Our Ref: R/2016/1/C
File No: MP 08_0098 MOD 13

Modification Request for The Star (MP08_0098 MOD 13) – 20-80 Pyrmont Street, Pyrmont

The City of Sydney (the City) has reviewed the information provided as part of the public exhibition and **objects** to the Section 75W modification of the project approval.

GOOD VENTILATION - 100% (Above Level 09)

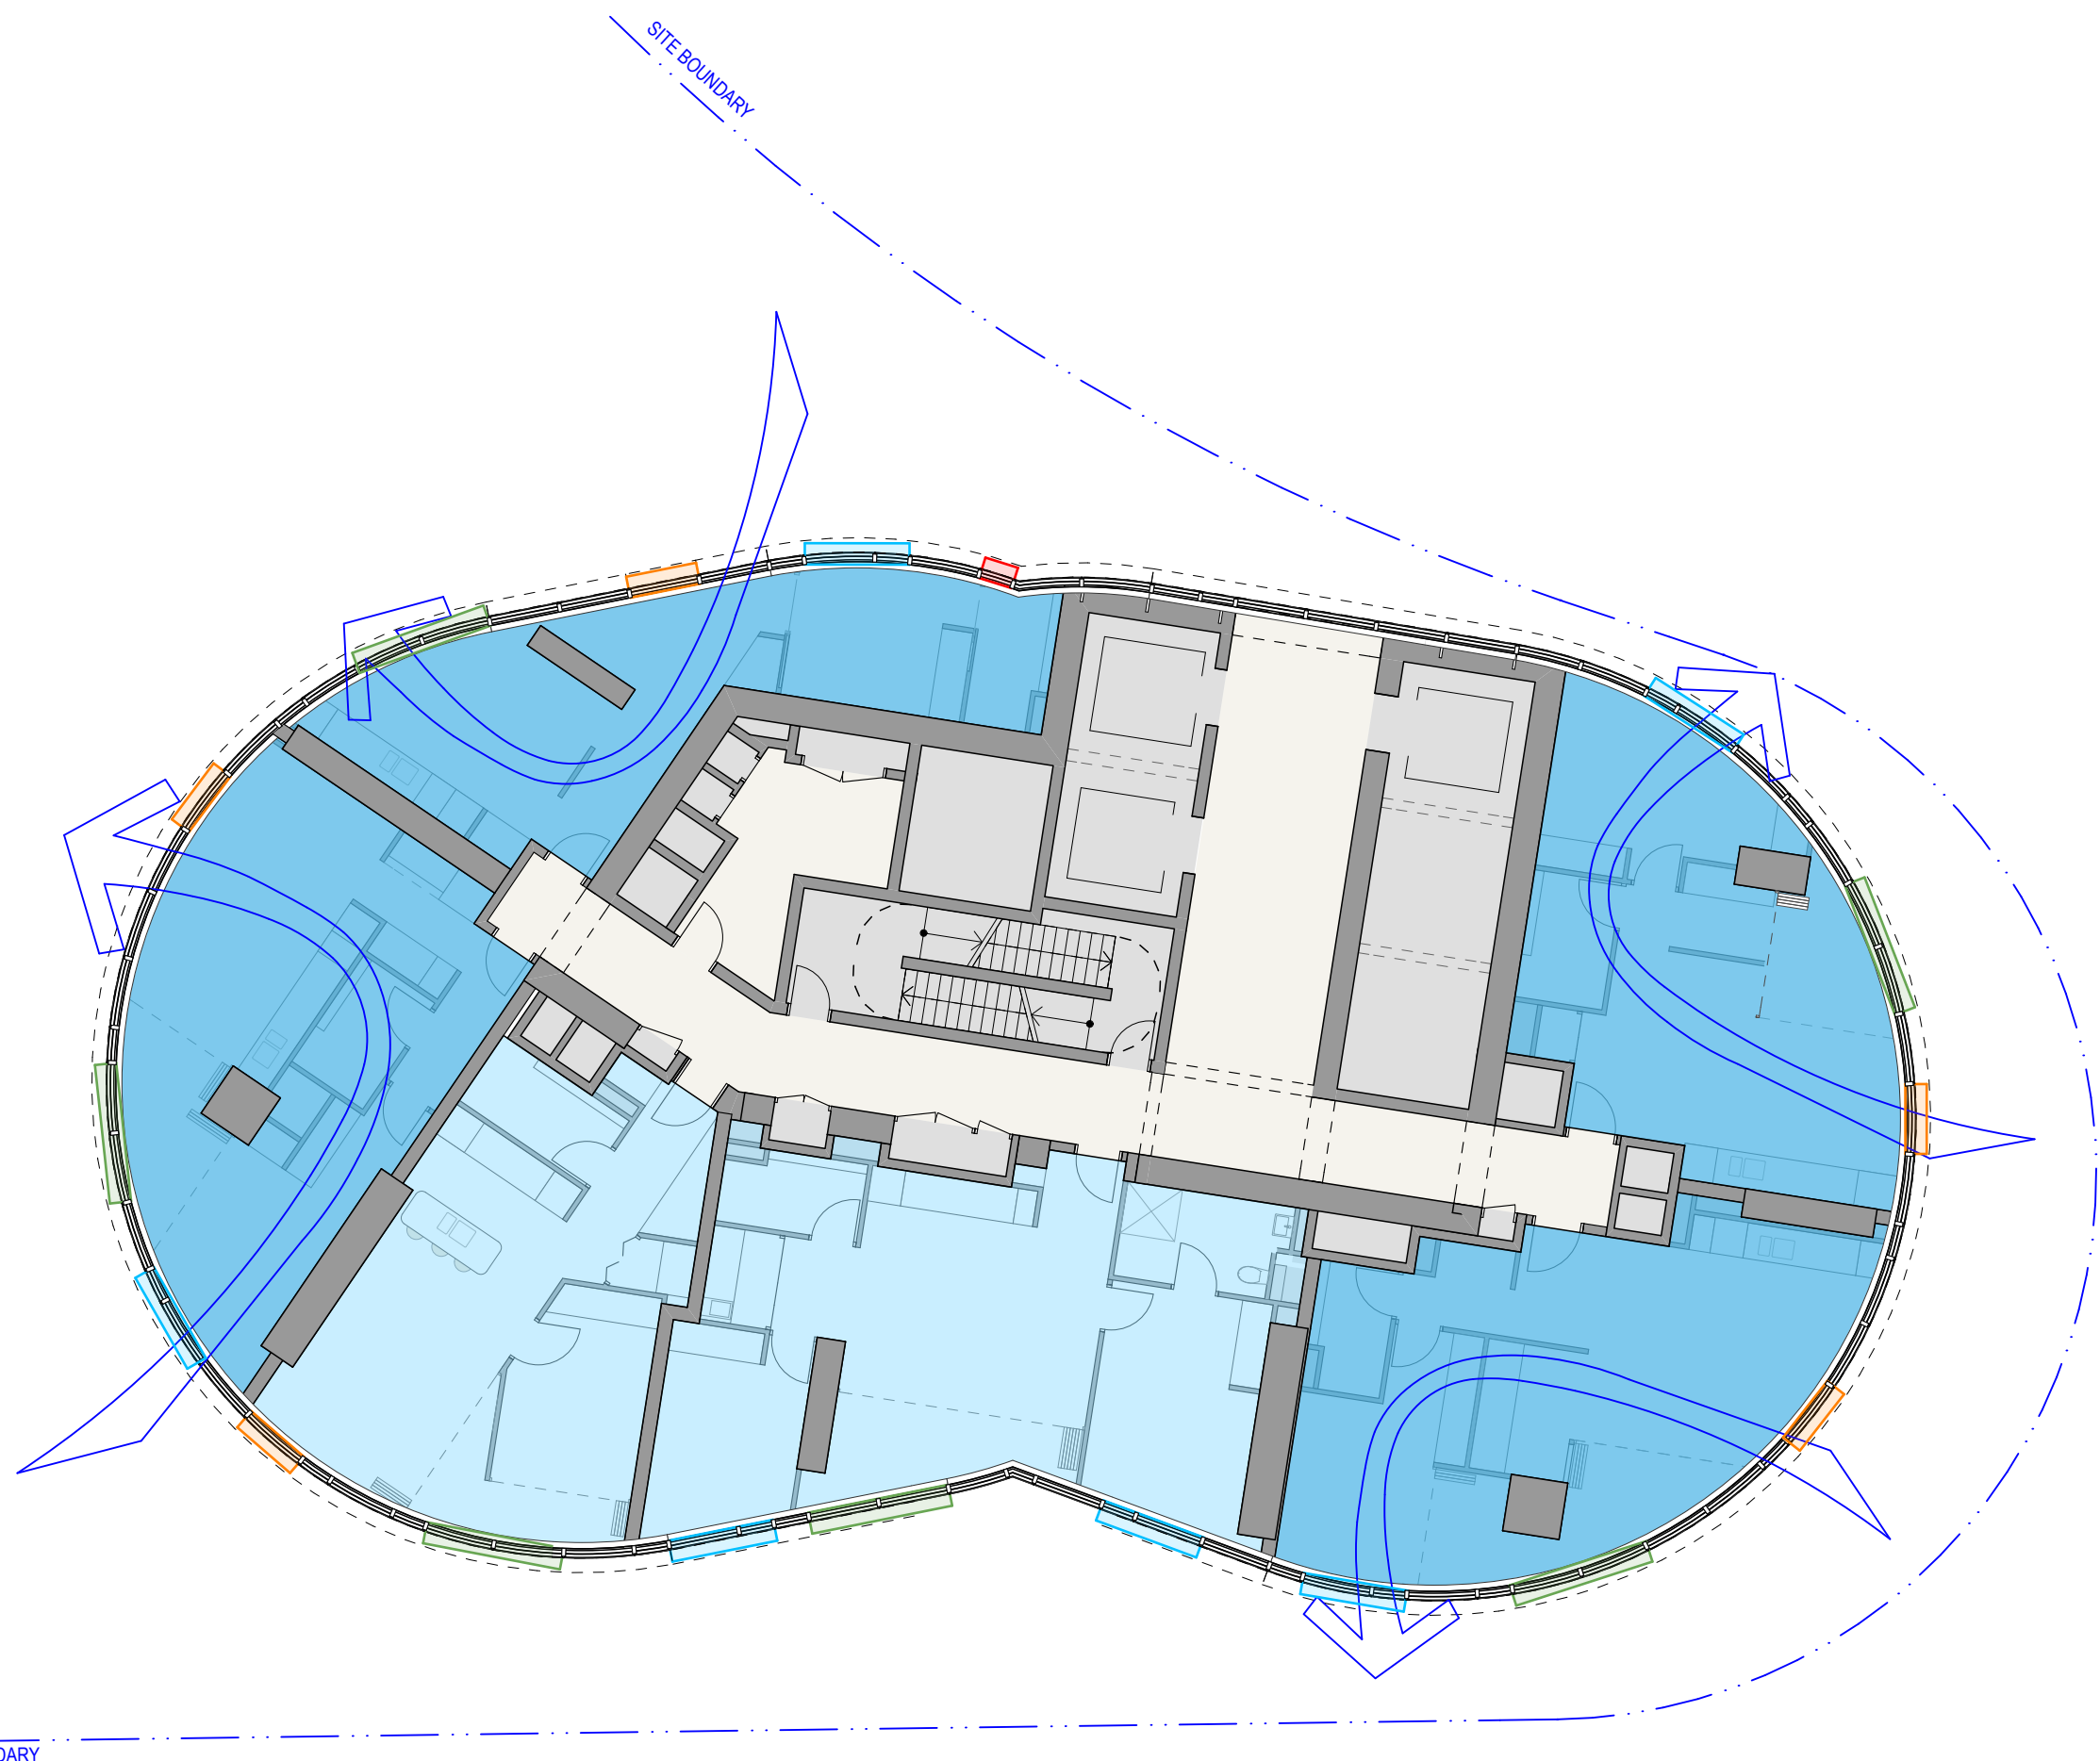
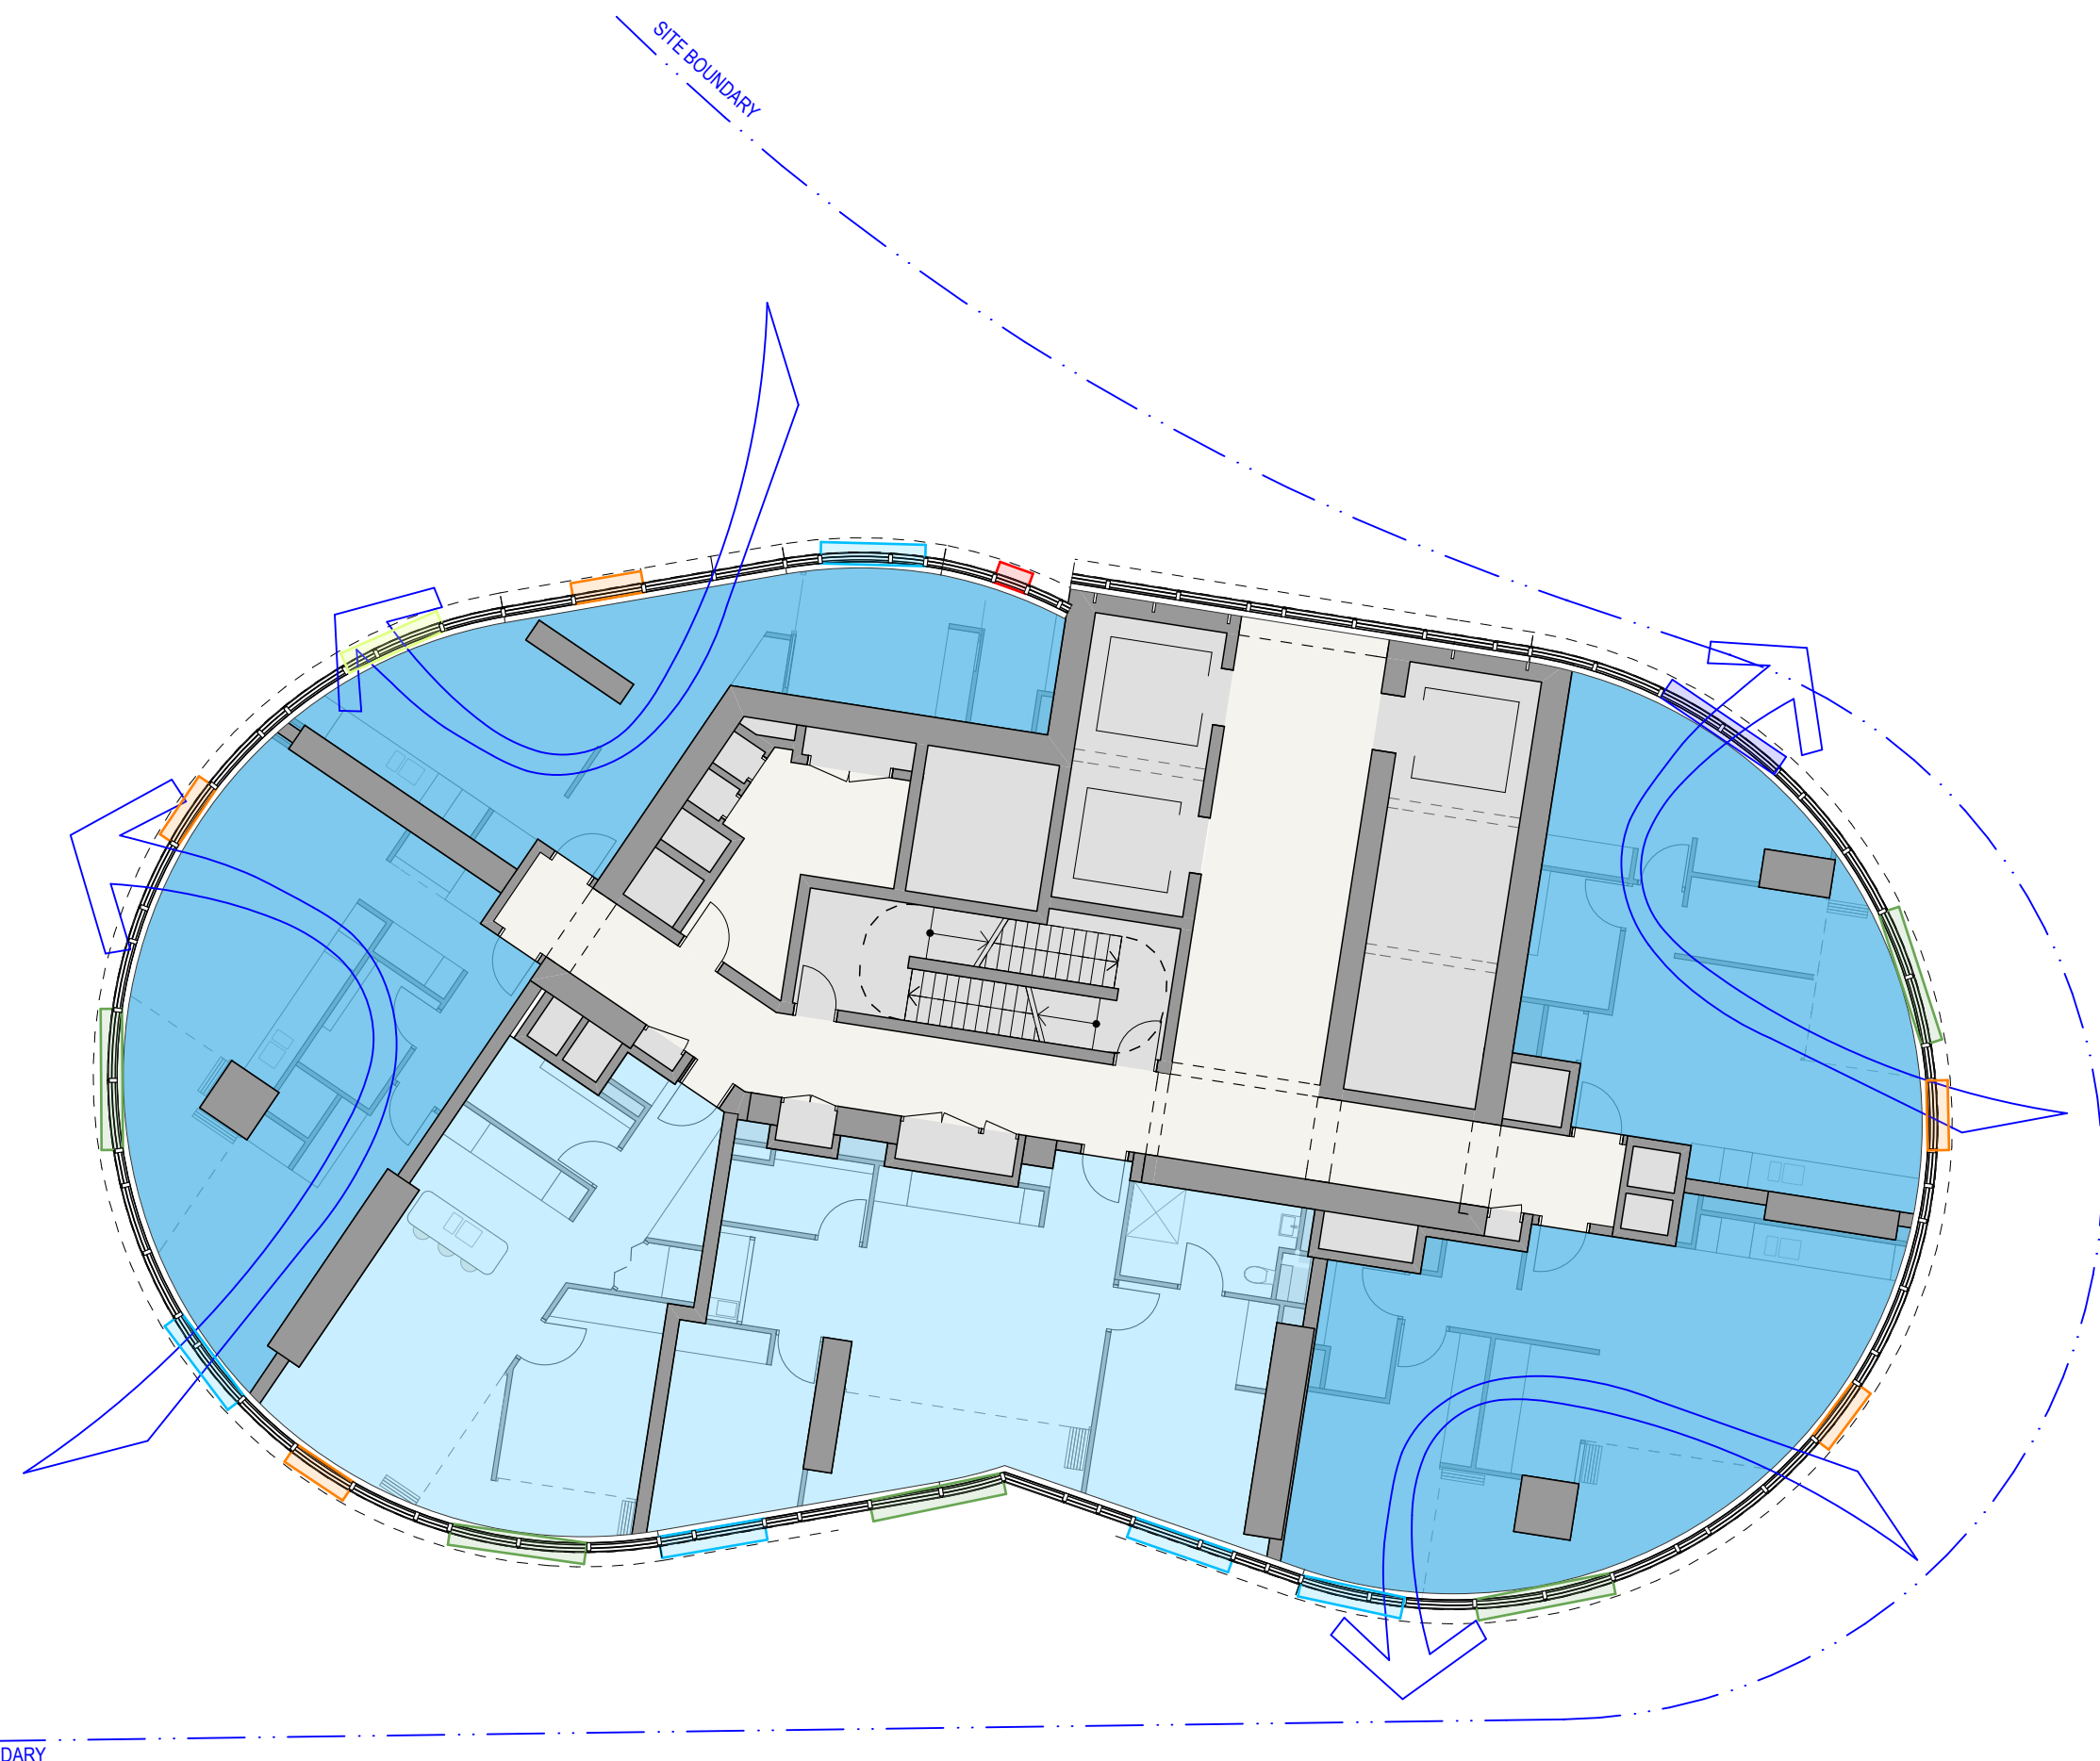
- Inadequate detail has been provided to establish how the natural ventilation requirements of the ADG will be met. The architectural plans do not show *any* operable windows to apartments. All glazing, including to wintergardens, is drawn in plan to appear as a curtain wall. This provides an unacceptable level of amenity.

- The Noise Impact Assessment states that all residential windows will need to remain closed with mechanical ventilation relied upon to meet required internal noise levels. This solution does not comply with Objective 4B-1 in the ADG requiring all habitable rooms to be naturally ventilated.

- 70% of apartments located below level 10 of the building are to be naturally cross ventilated. Due to the apparent curtain wall sealing all windows, no apartments appear to be naturally cross ventilated.
